Submission

Applicant – Bowdens Silver Pty Limited
Application Number - SSD-5765
Application – Bowdens Silver Mine

I comment on the Amendment Report which seems to be a new EIS submission requesting submissions commenting on the construction of a new 500kV Transmission Line at the proposed mine site and other changes to the EIS including the Tailings Dam (TSF), and submissions commenting on the EIS.

Figure 1.2
EXISTING AND PROPOSED ALIGNMENT
OF THE 500KV TRANSMISSION LINE

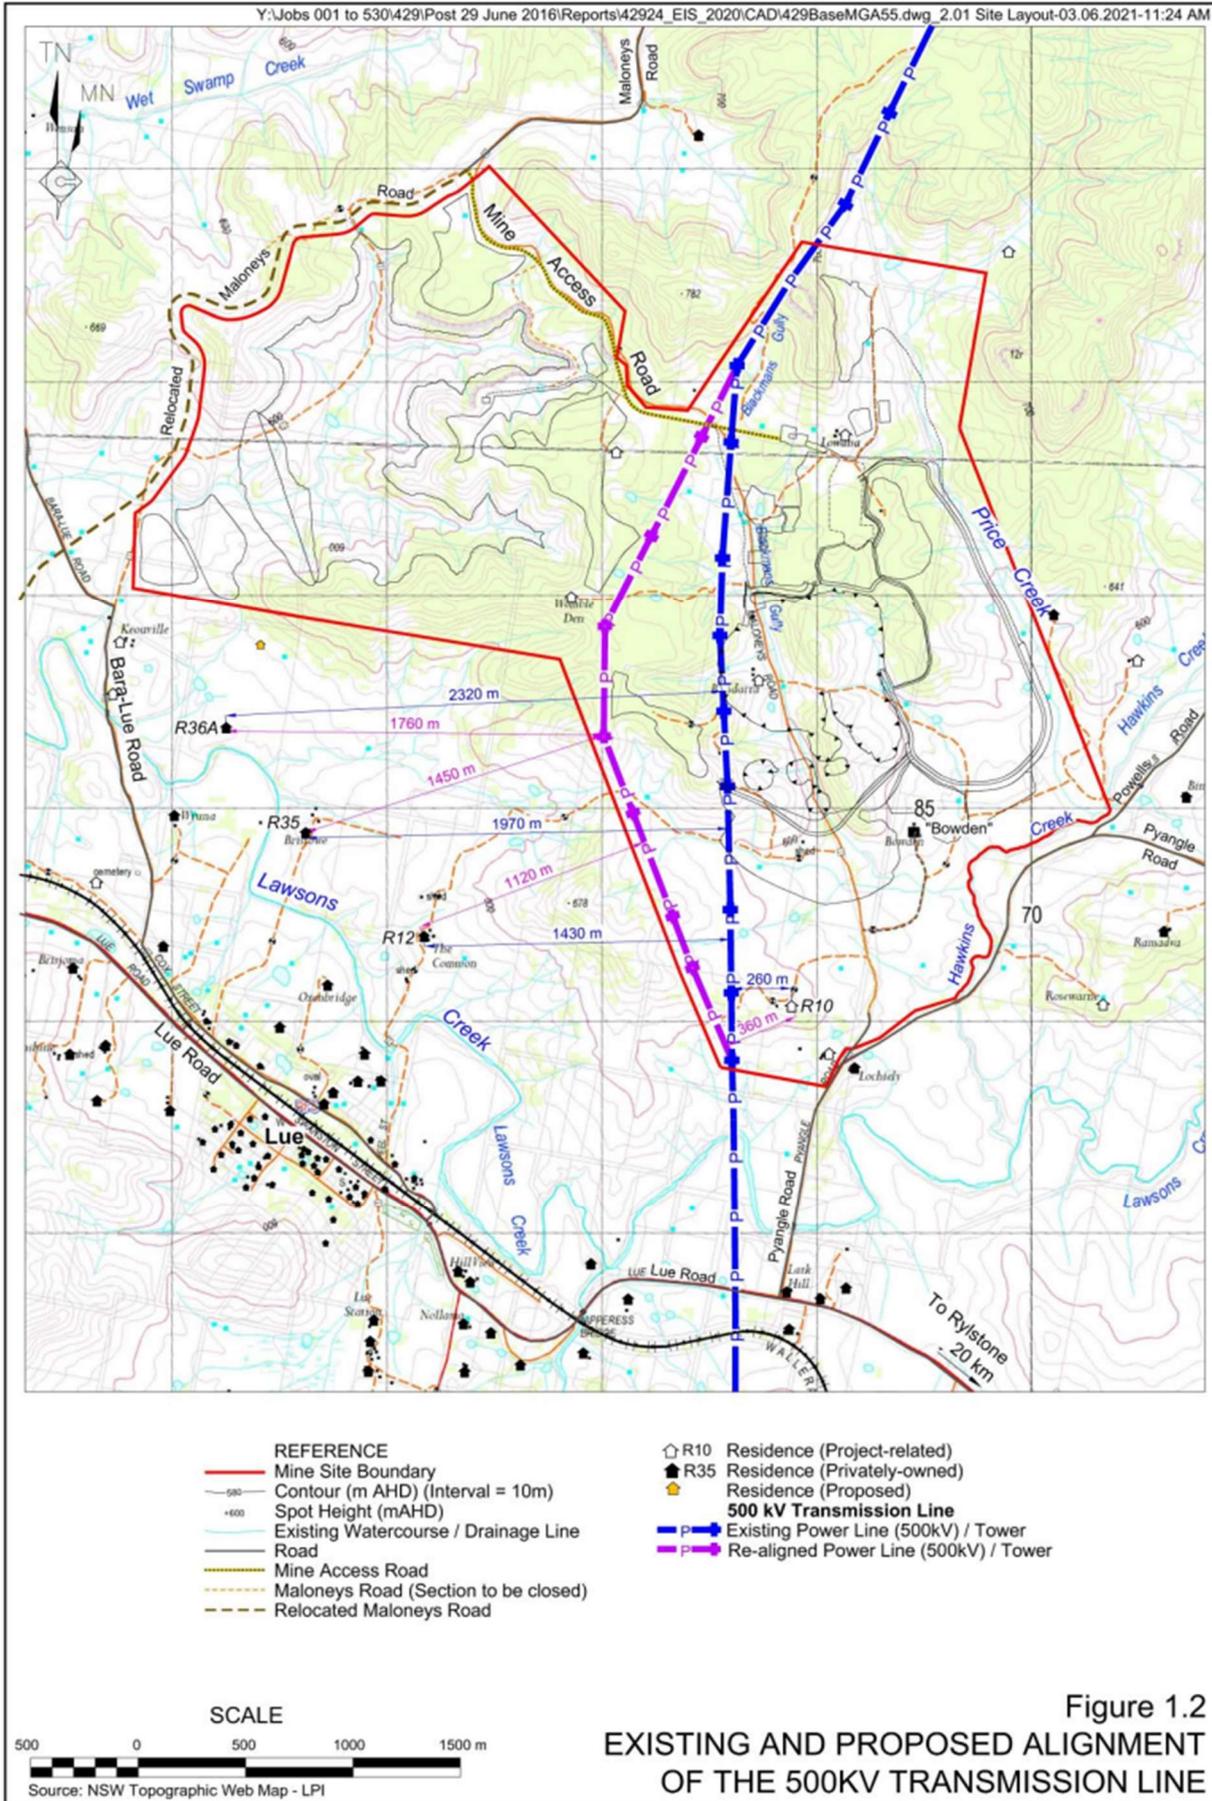
On one map the Transmission Line is shown as completed at the end of the construction phase, on another there are no homes shown on the map, Figure 1.2, a map of the Proposed and Existing Transmission Line does not show my home and some homes in Lue are also not shown.
